CITY OF ALBUQUERQUE

**RE: Suazo Residence Lot 8 Block 10 Unit 22 Volcano Cliffs
6511 Petirrojo NW
Grading and Drainage Plan
Engineers Stamp Date 1/15/16 (D10D0003P8)**

ENGINEER'S SEAL  1/20/16 1/15/16 DAVID SOULE P.E. #14522	LOT 8, BLOCK 10, UNIT 18 VOLCANO CLIFFS SUBDIVISION  GRADING AND DRAINAGE PLAN   <i>Rio Grande Engineering</i> 1606 CENTRAL AVENUE SE SUITE 201 ALBUQUERQUE, NM 87106 (505) 872-0999	DRAWN BY JDG  DATE 01-14-2015
		SHEET # 1 OF 1  JOB #

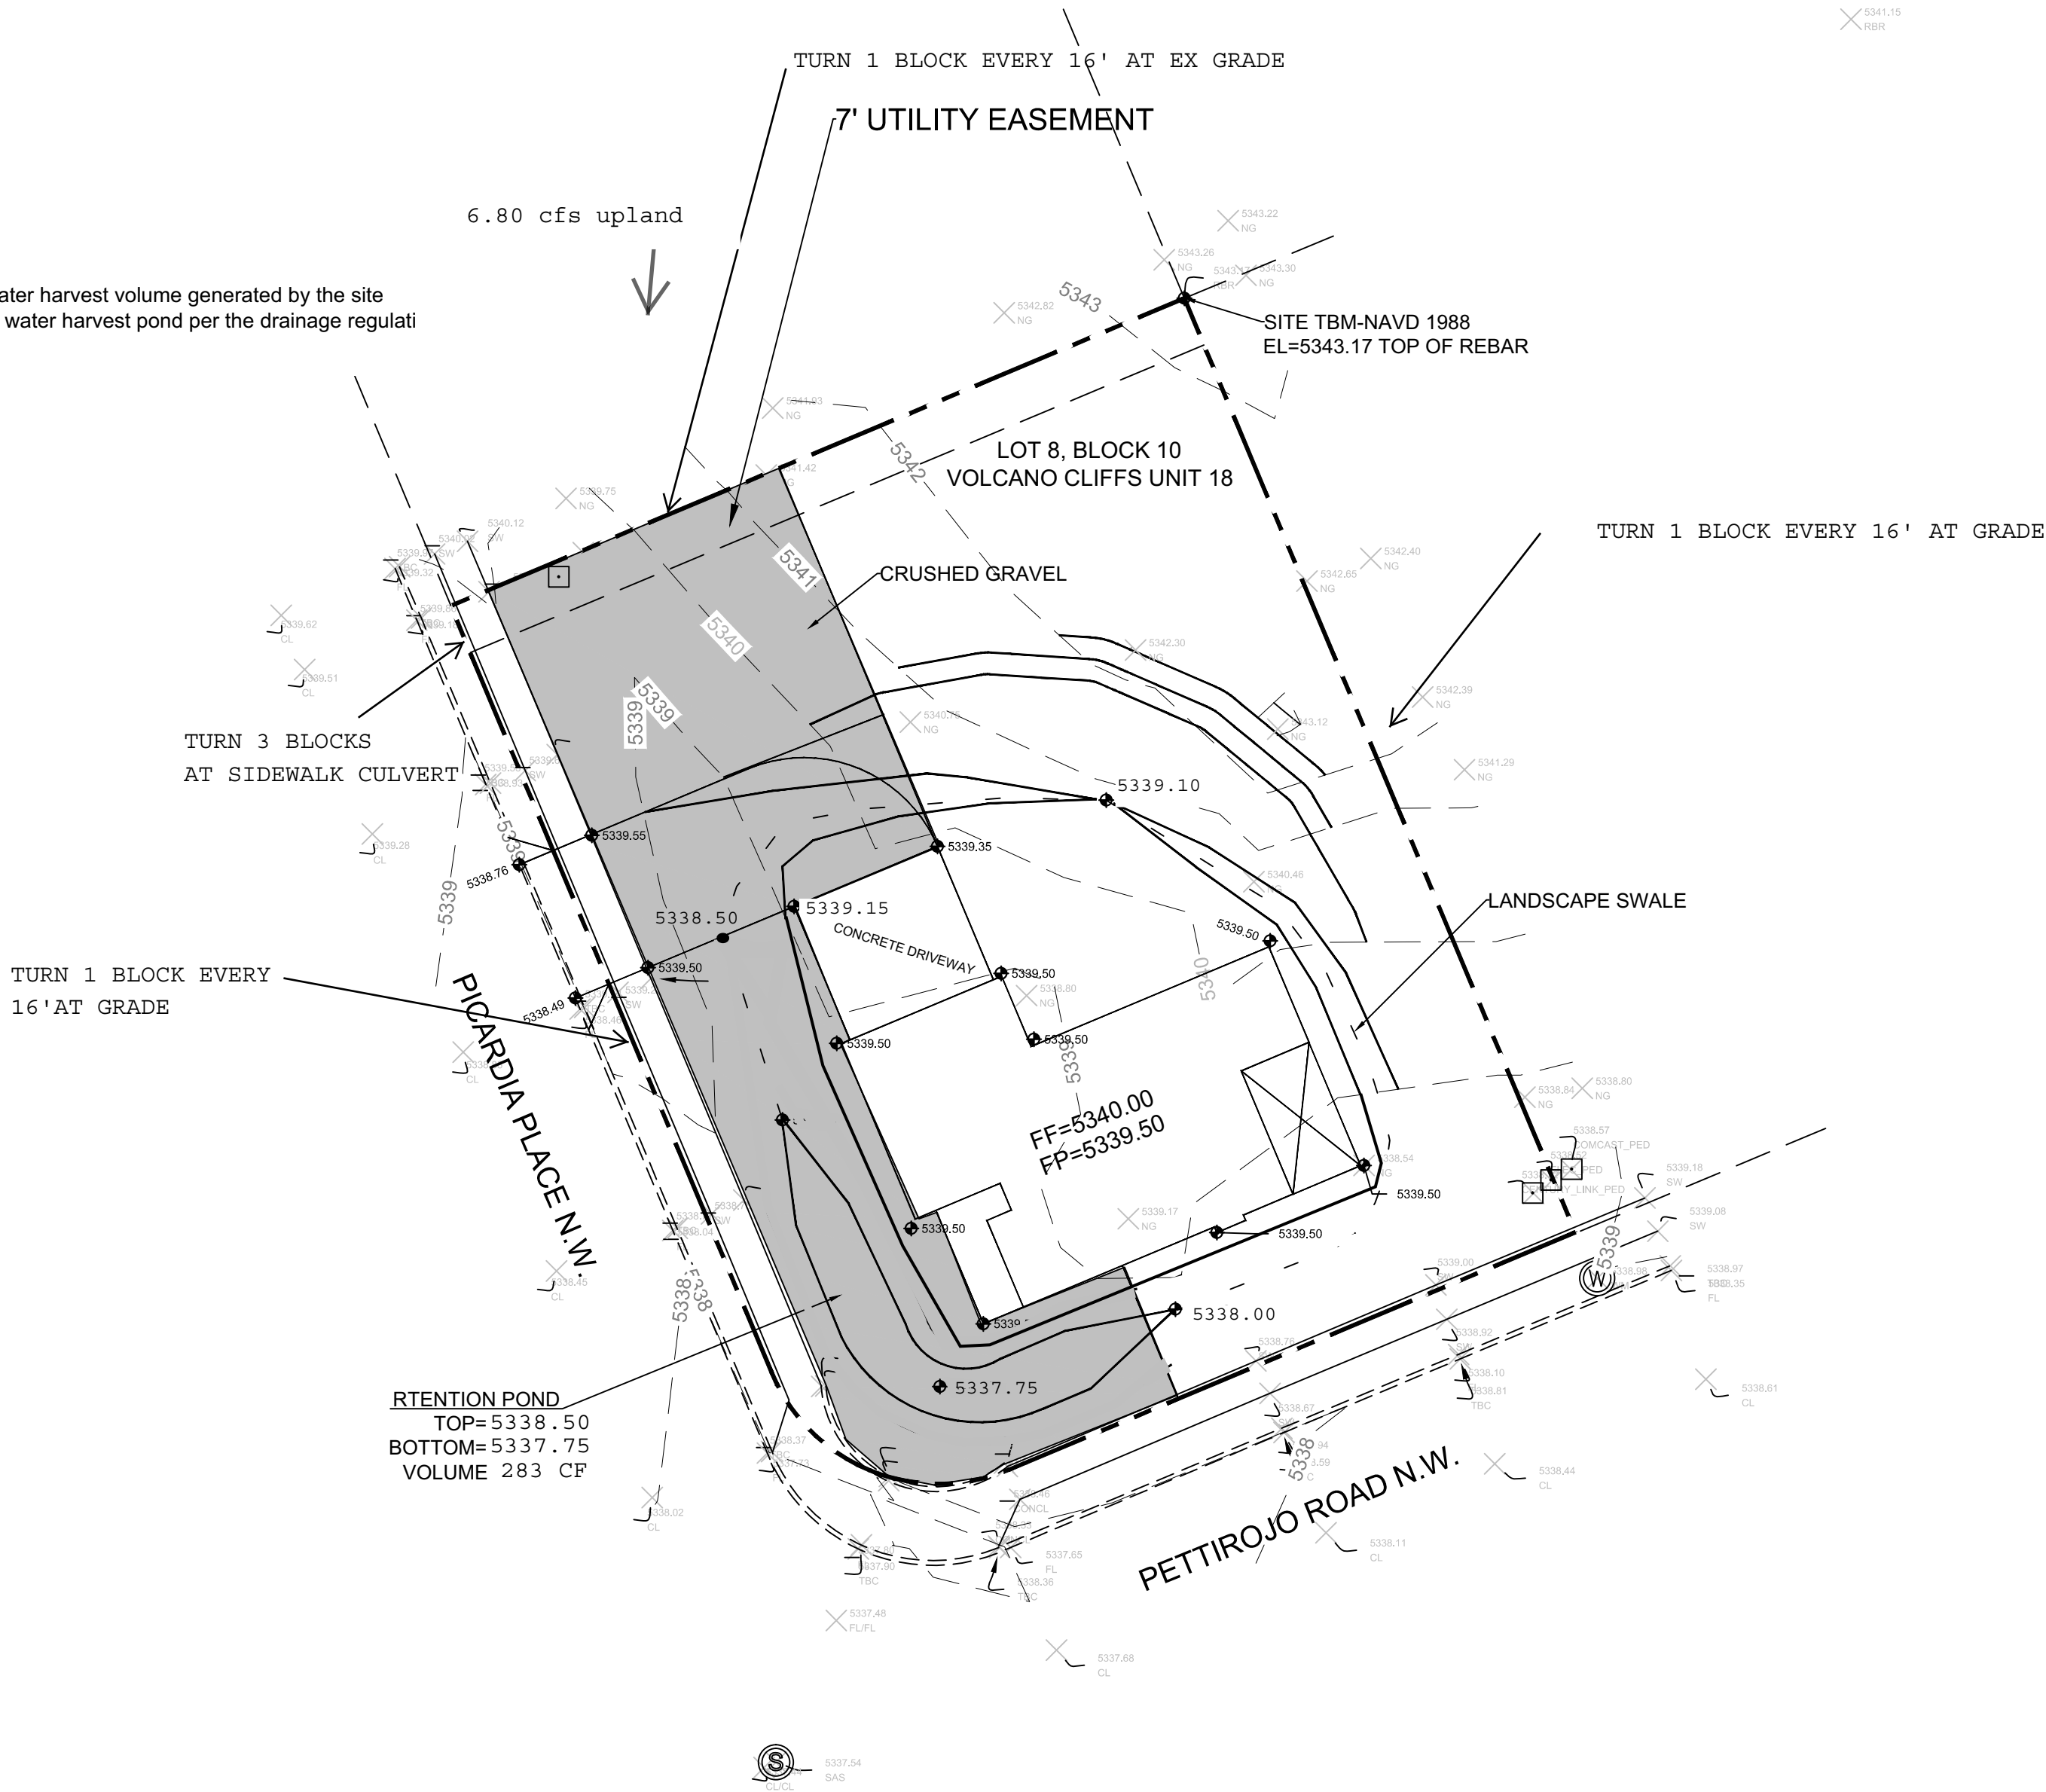
- Provide turn blocks in the east and west rear yard walls to allow flows to pass through and into the double sidewalk culvert in Picardia Place.
